From:
To: [DCAdmin](#)
Subject: Planning Application 2022/91604 - comments
Date: 28 May 2022 15:07:18

Re: Planning Application 2022/91604

I understand that a new application for 3 dwelling flats has been made for 66 Blacker Road - 2022/91604.

PROPOSED REAR ELEVATION

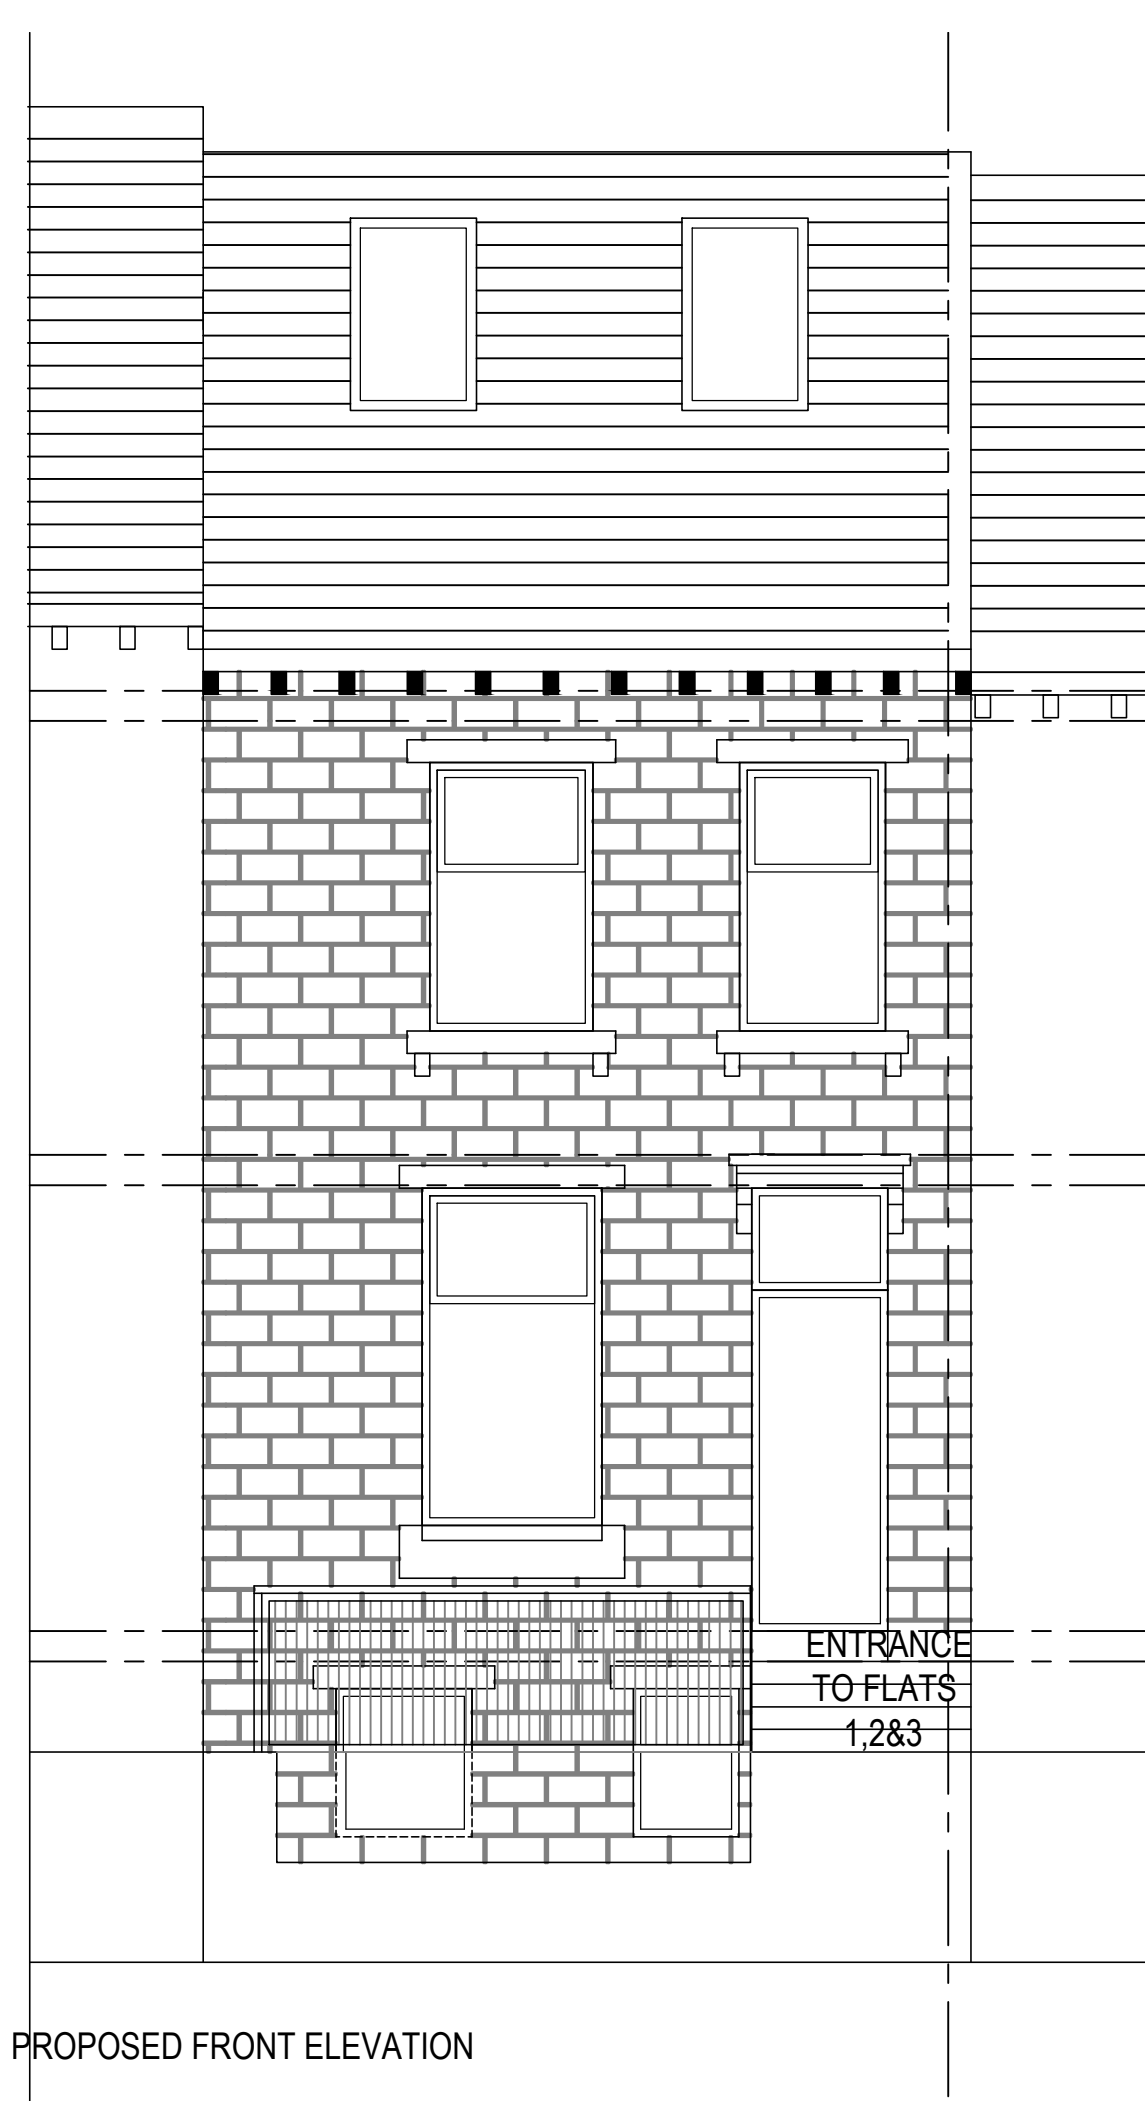
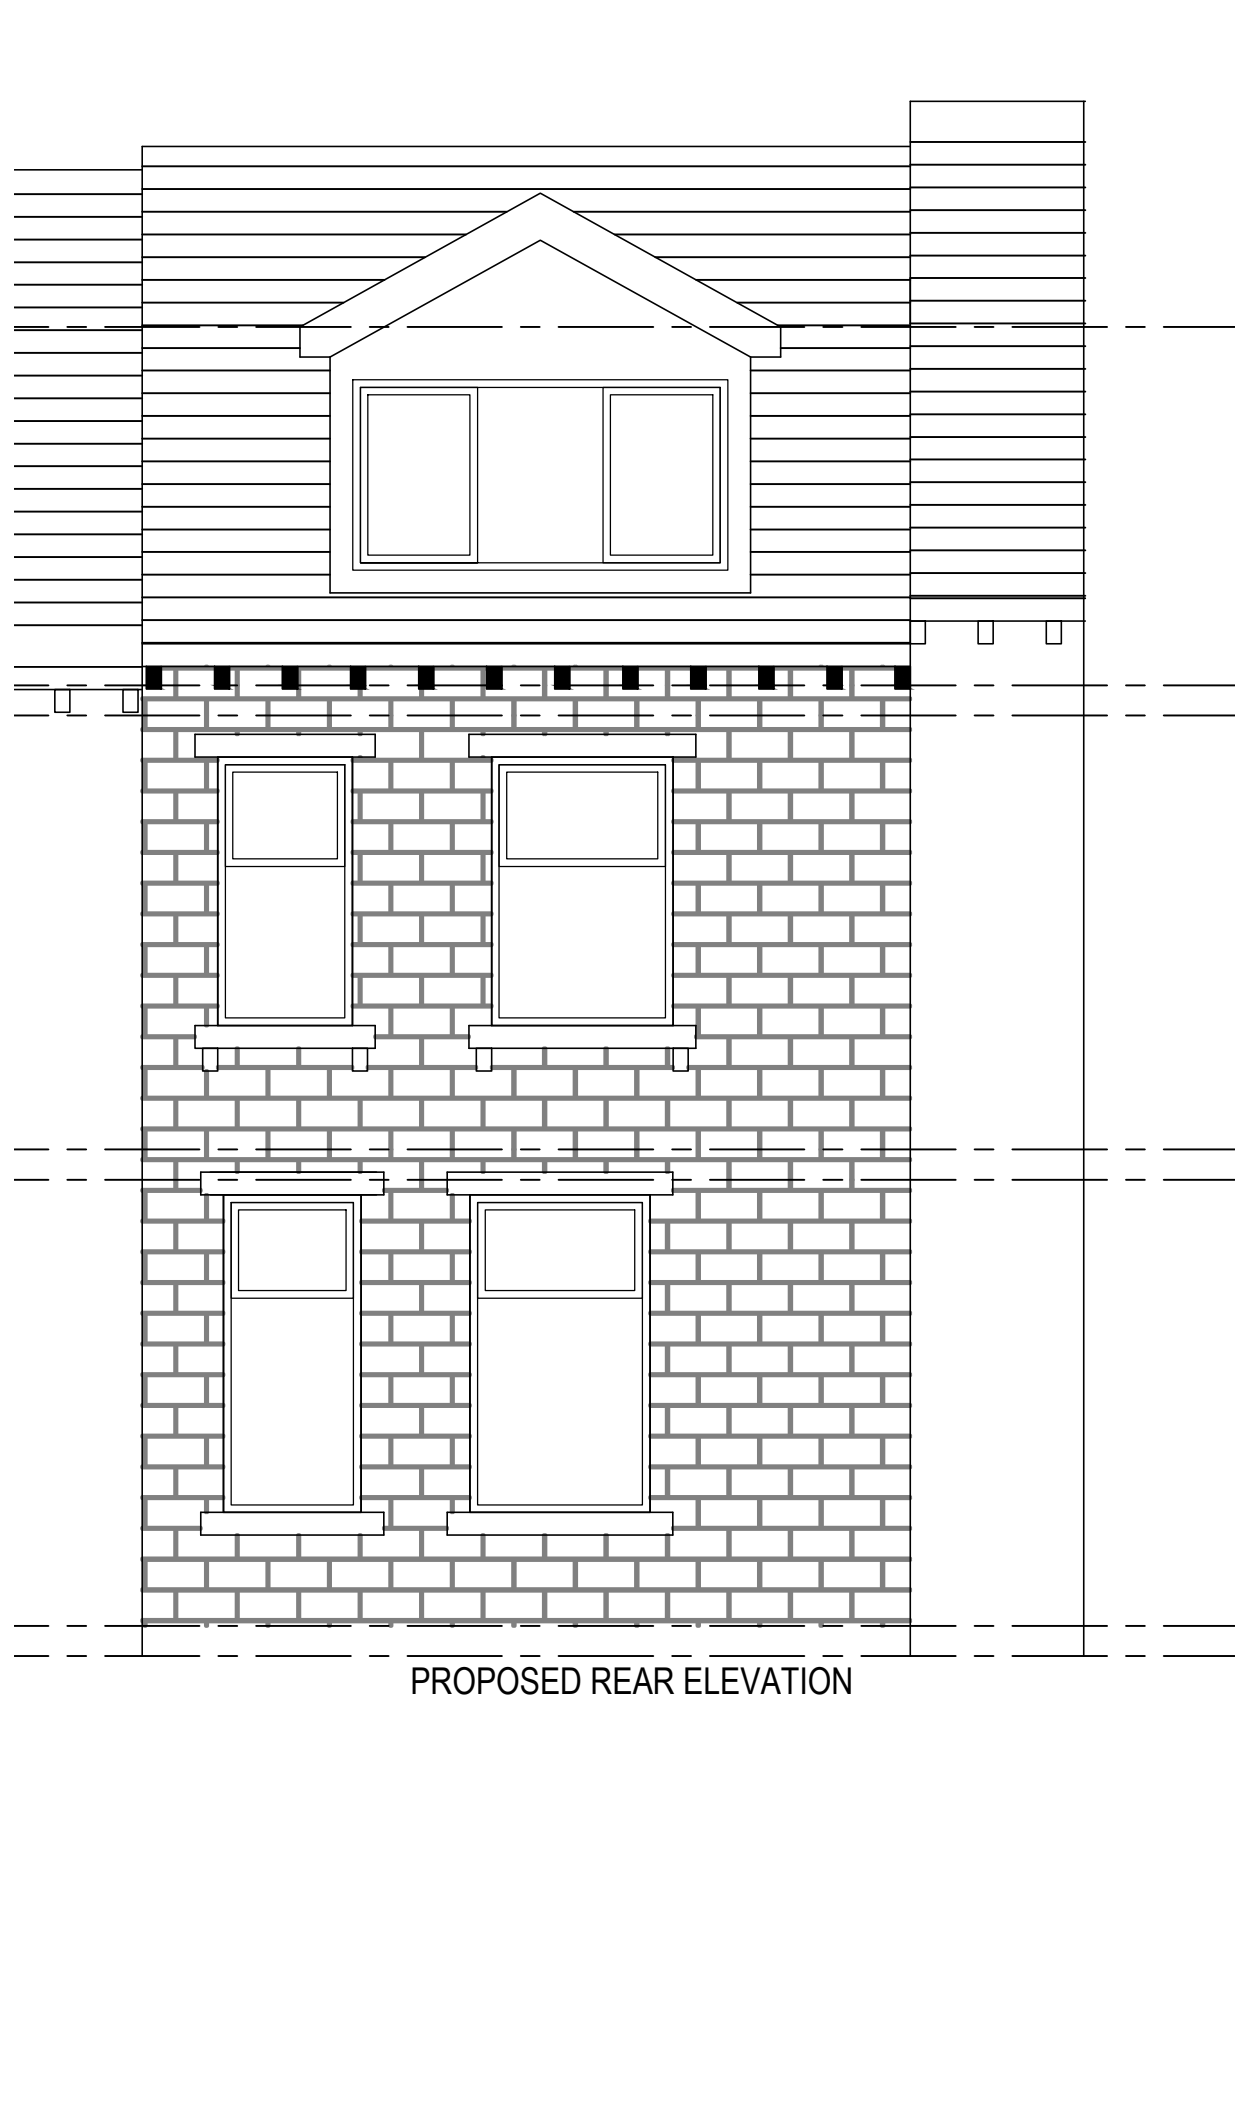
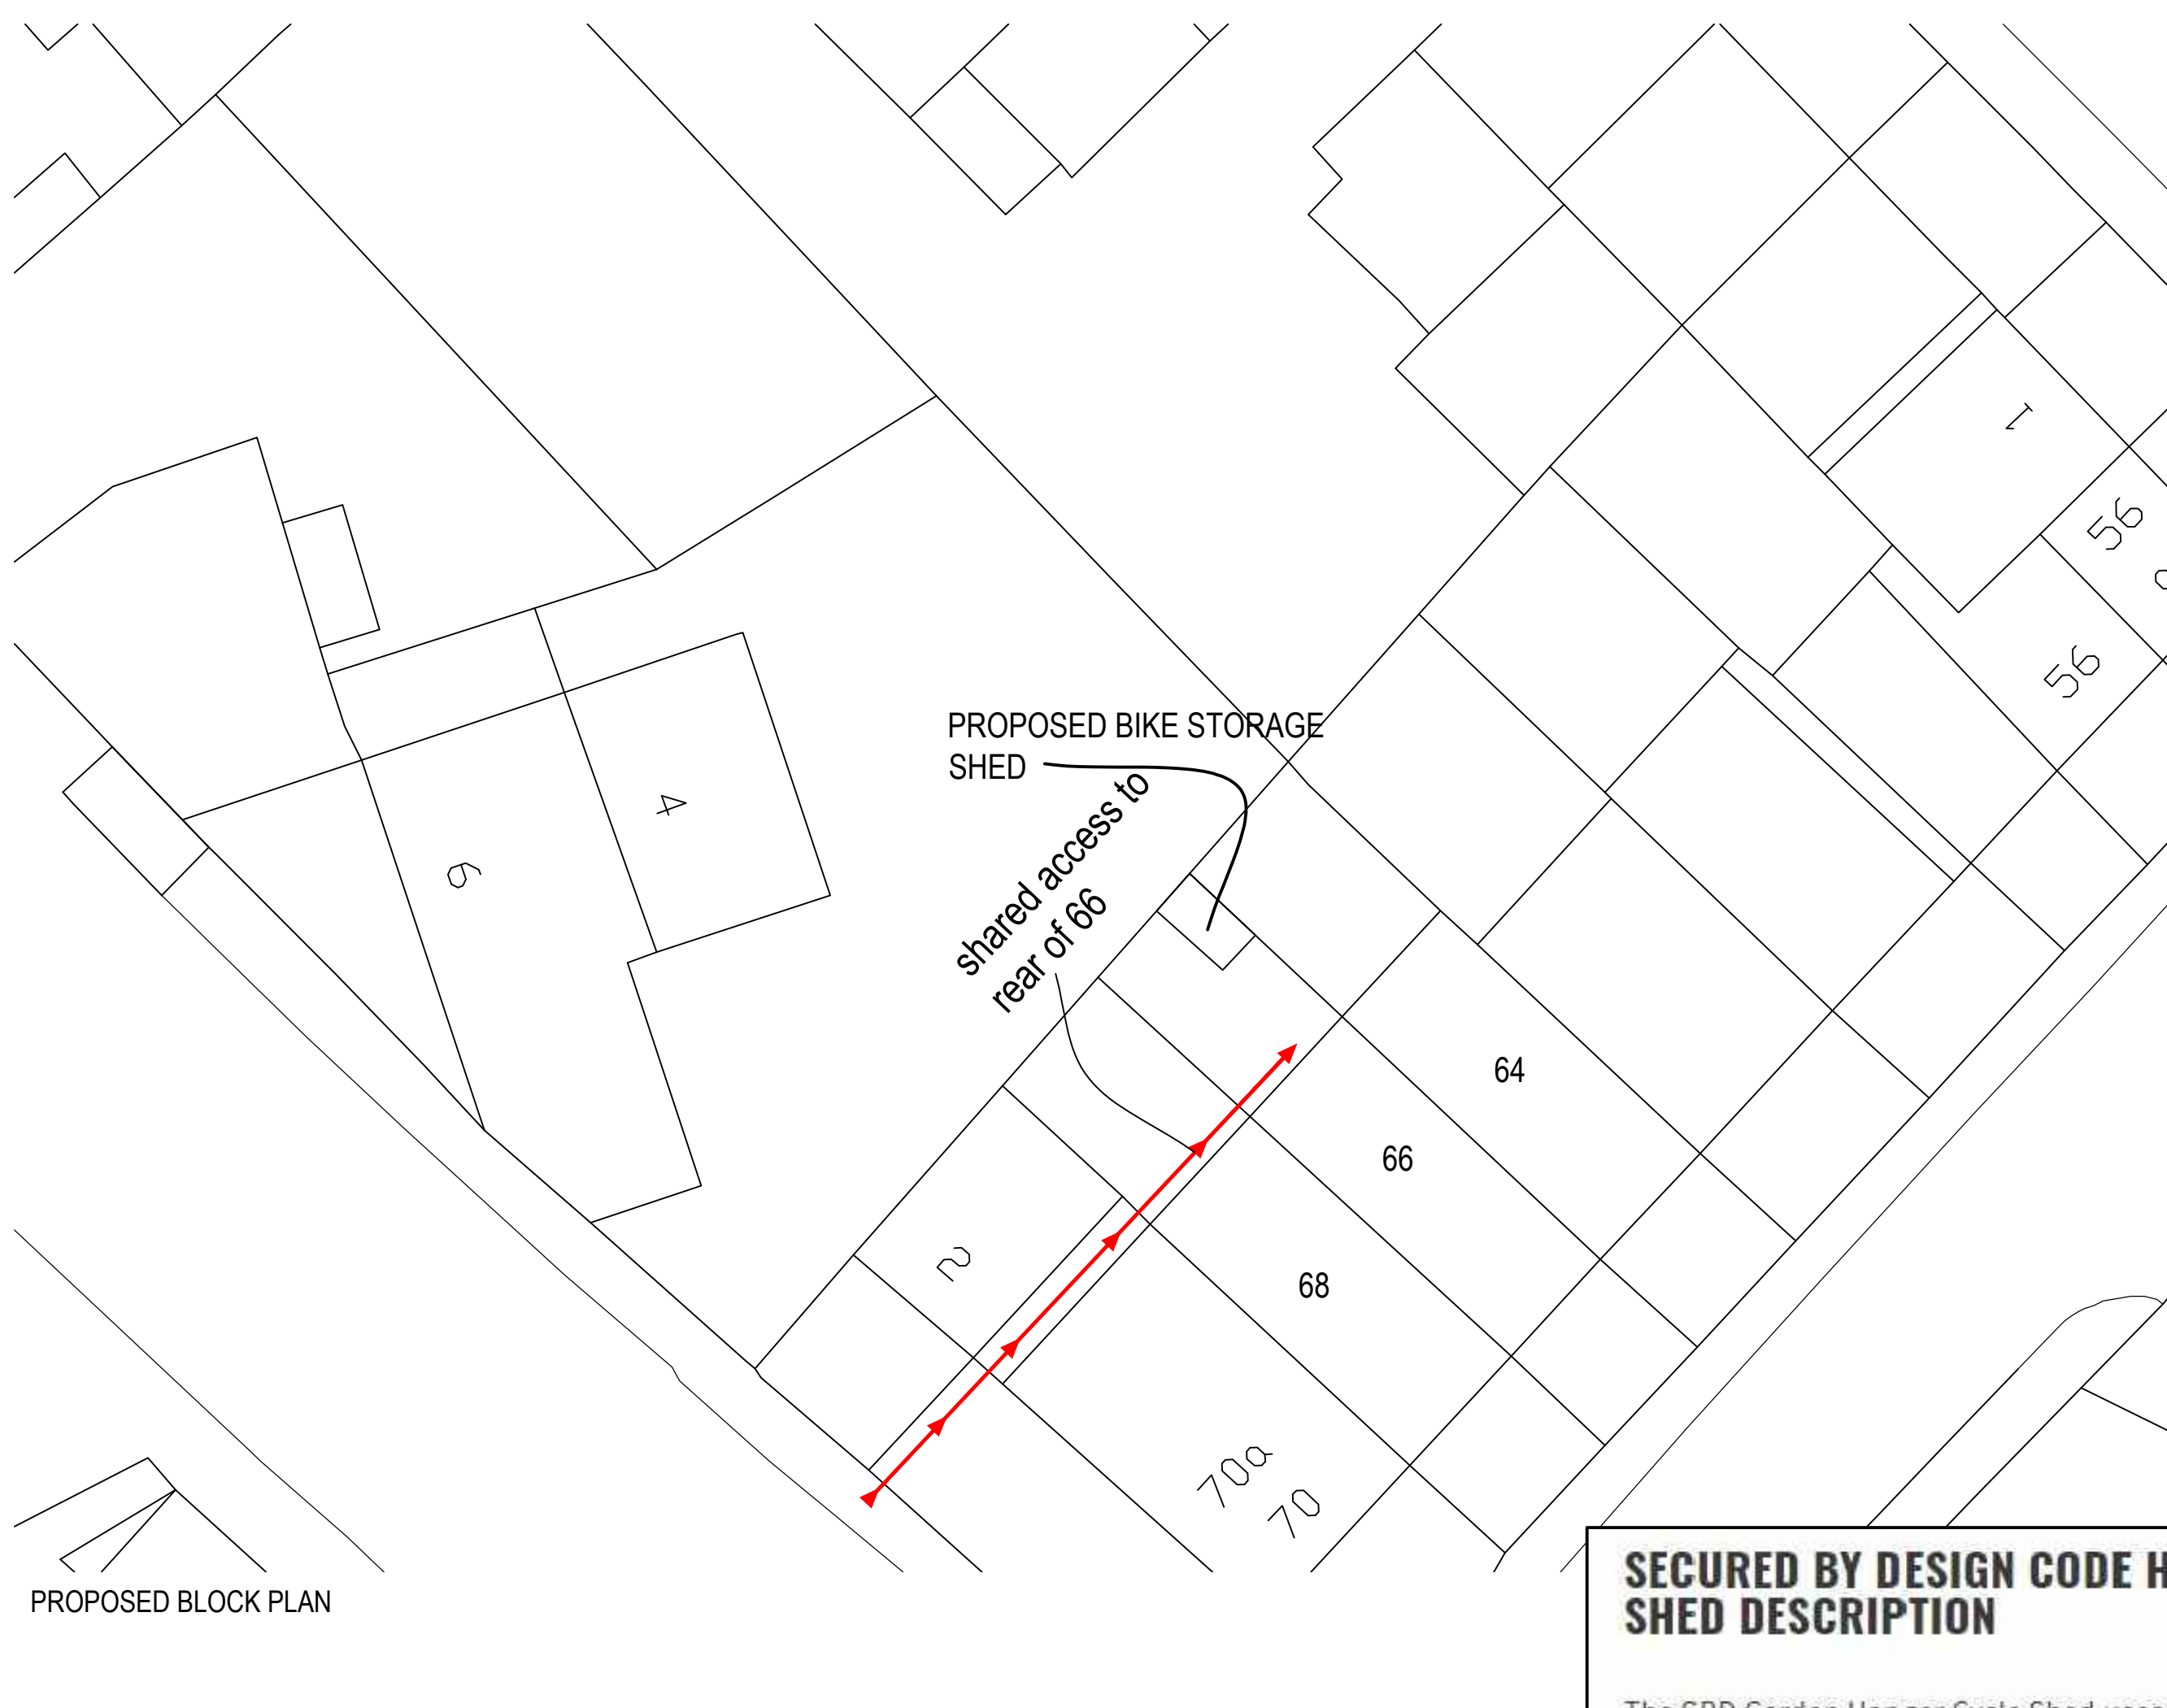
- The proposed dormer/attic extension and second floor flat conversion will directly overlook, and detrimentally affect the privacy of
 - The layout of the 3 flats will mean that main socialising areas (kitchens/living areas) for at least 2 separate occupants will provide a view which directly overlooks detrimentally affecting our privacy

- Number 66 Blacker Road squarely faces in the area where it receives the most direct daytime sunlight, and thus where throughout the day and evening
 - The proposed dormer/attic extension will directly affect the amount of sunlight coming , in the exact relative position where we have our

- The proposed dormer/attic extension is not in keeping with the design or aesthetics with the majority of neighbouring properties, and lays within a conservation area.
